## Questions posed to the IP's from the ExA

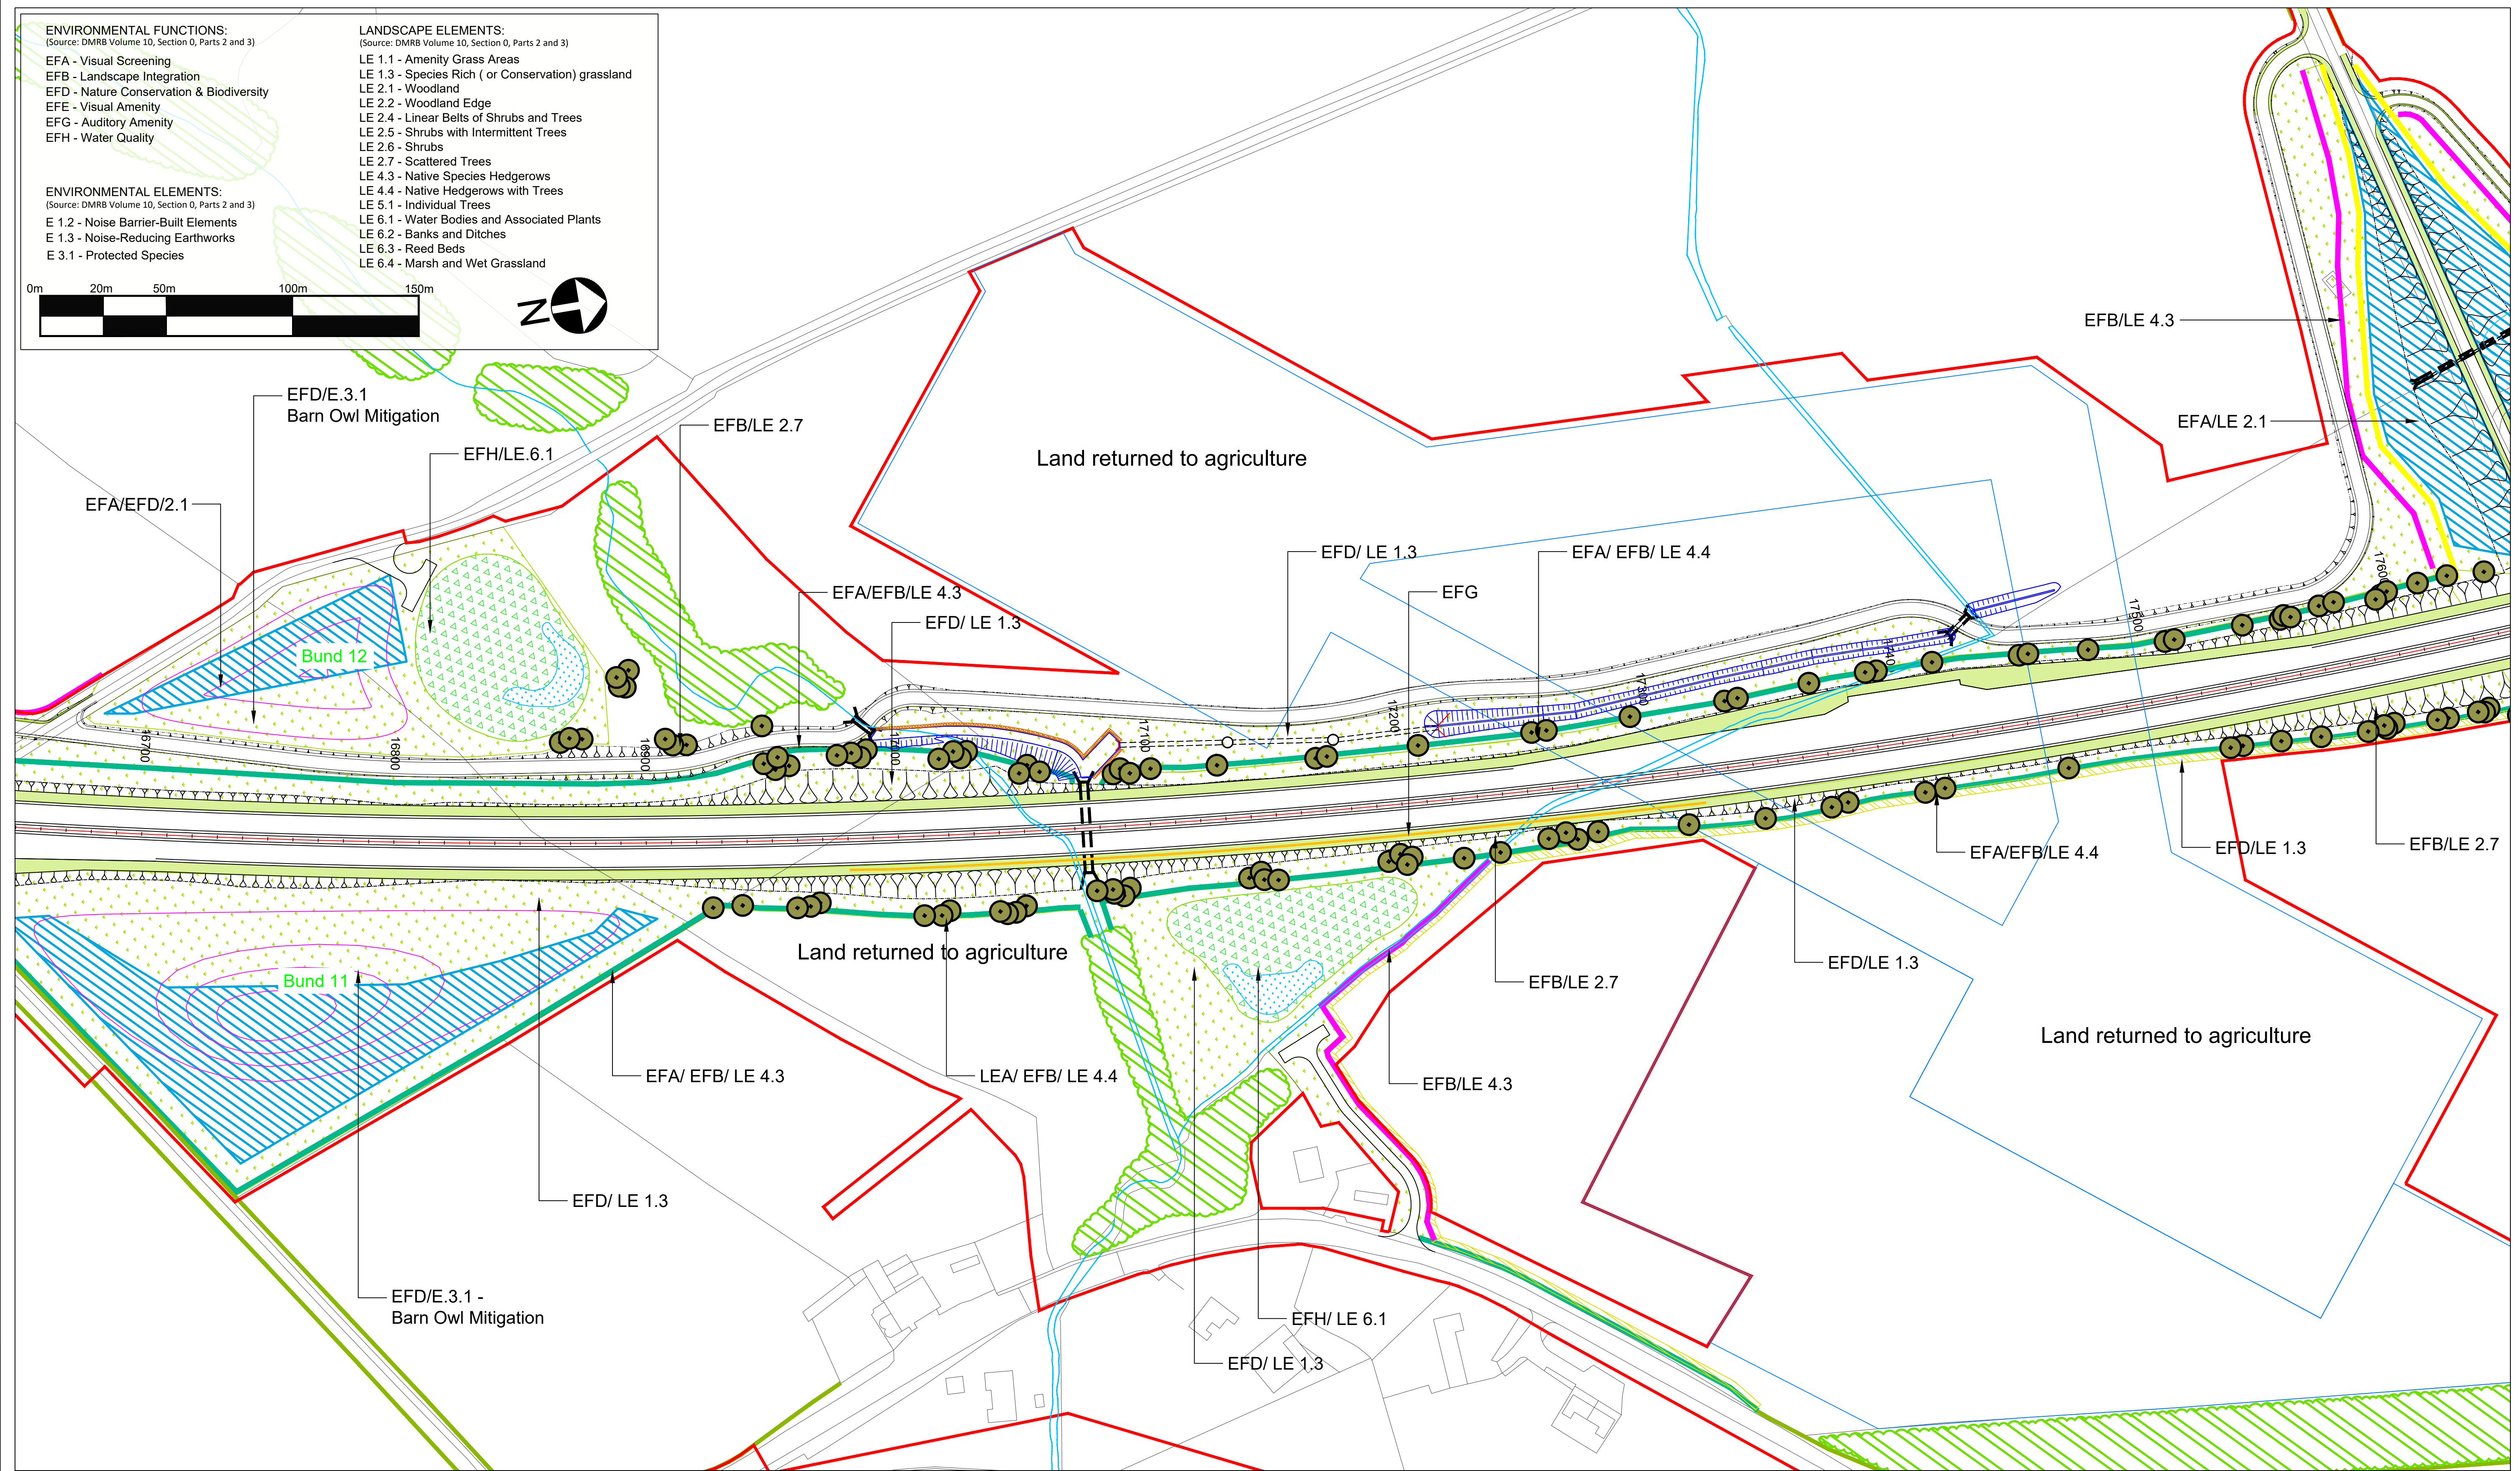
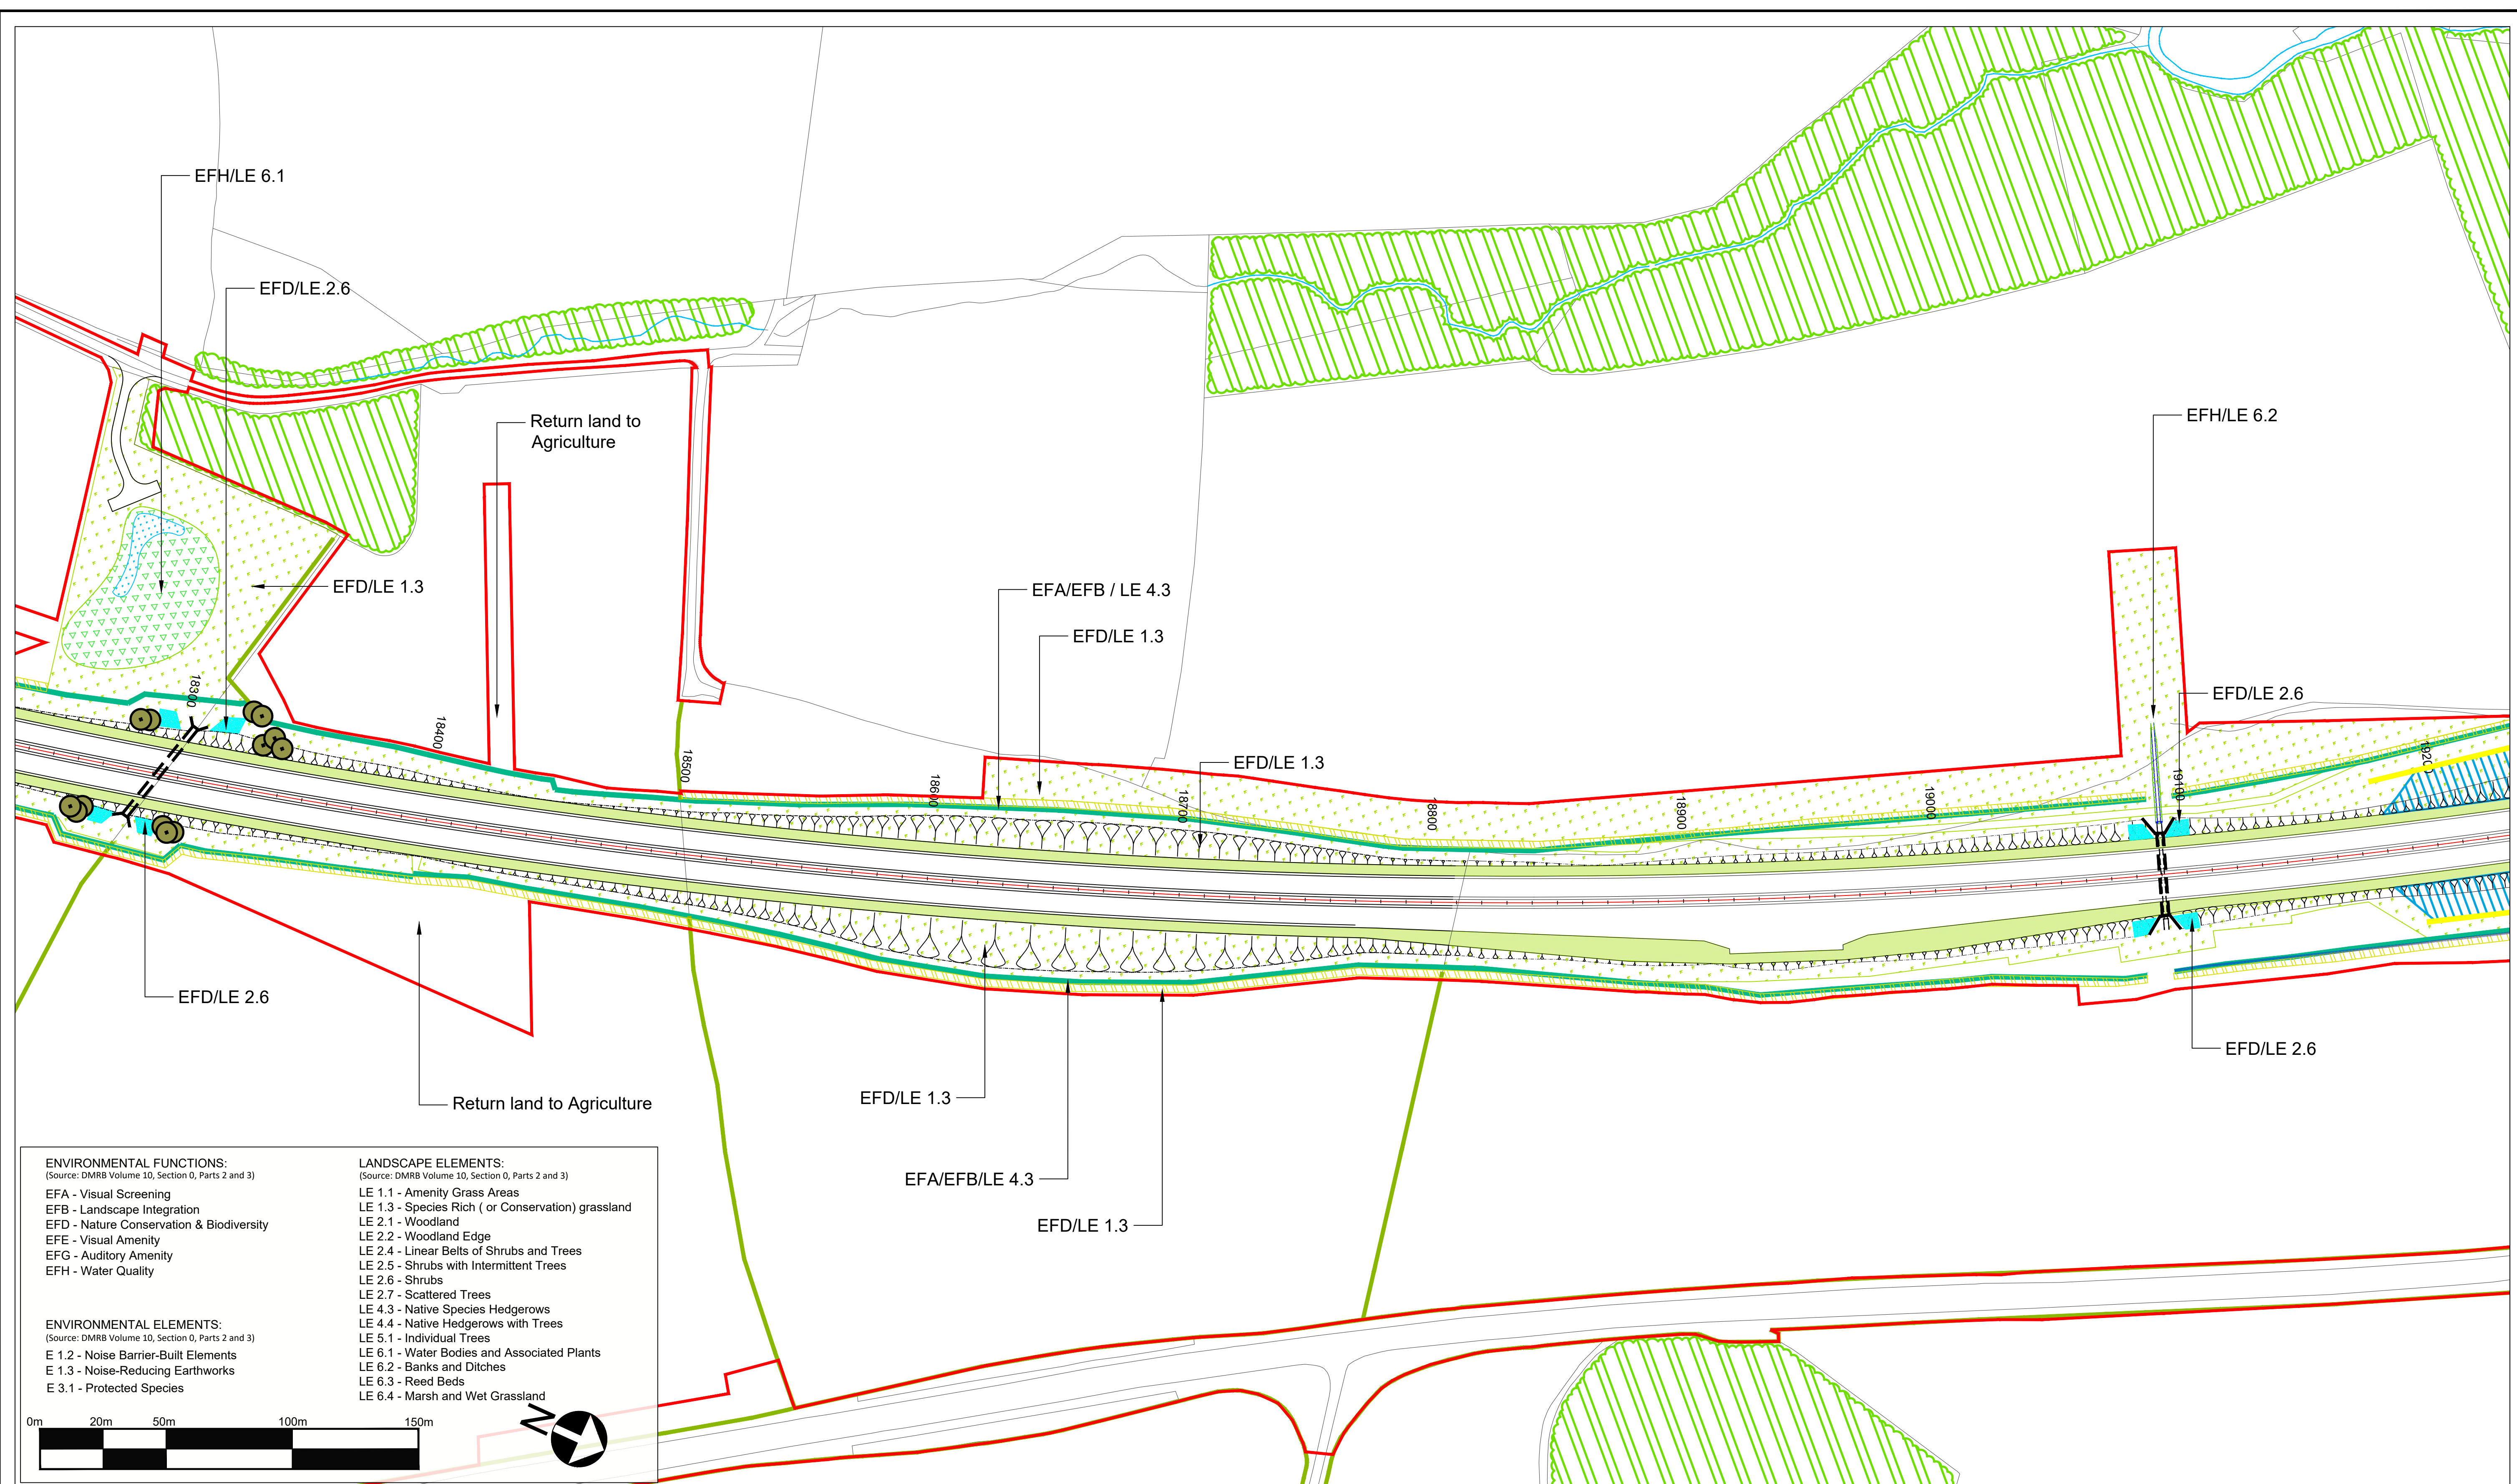
1. Whilst it is positive to see the detail of the landscape mitigation principles, I am struggling to see this approach reflected in the actual plans detailed in APP-095.
2. As I have a number of outstanding queries relating to the Masterplan, I would welcome further detail and context provided by a landscape and ecological management plan.
3. As the current plans involve major detrimental changes to the landscape that I currently enjoy I have raised a number of concerns and queries with the Applicant on this topic in May 2020 which remain outstanding. I am hopeful that a scheduled meeting with the Applicant will help answer the queries.

1. Unfortunately, the Landscape Mitigation Masterplan shown in APP-095 is a major source of frustration and disappointment as I believe that it falls well short of what should be achieved to address landscape and ecological features.

2. In considering my property, as an example, the plans involve major changes to the to a picturesque landscape on all sides of the property. The current outlook from my property which includes mature woodlands and a pleasant tree lined avenue is to be replaced with 7 lanes of tarmac including a layby and access roads. The Landscape Masterplan offers very little mitigation to offset the detriment to visual effect. The sense of frustration is further exacerbated when the impact on the landscape visual is categorised as being slight.

1. As the plans involve major detrimental changes to the landscape that I currently enjoy I have raised a number of concerns and queries with the Applicant on this topic in May 2020 which remain outstanding. As some of my queries relate to the use of keys in the plans, I would welcome any additional information to help my understanding.
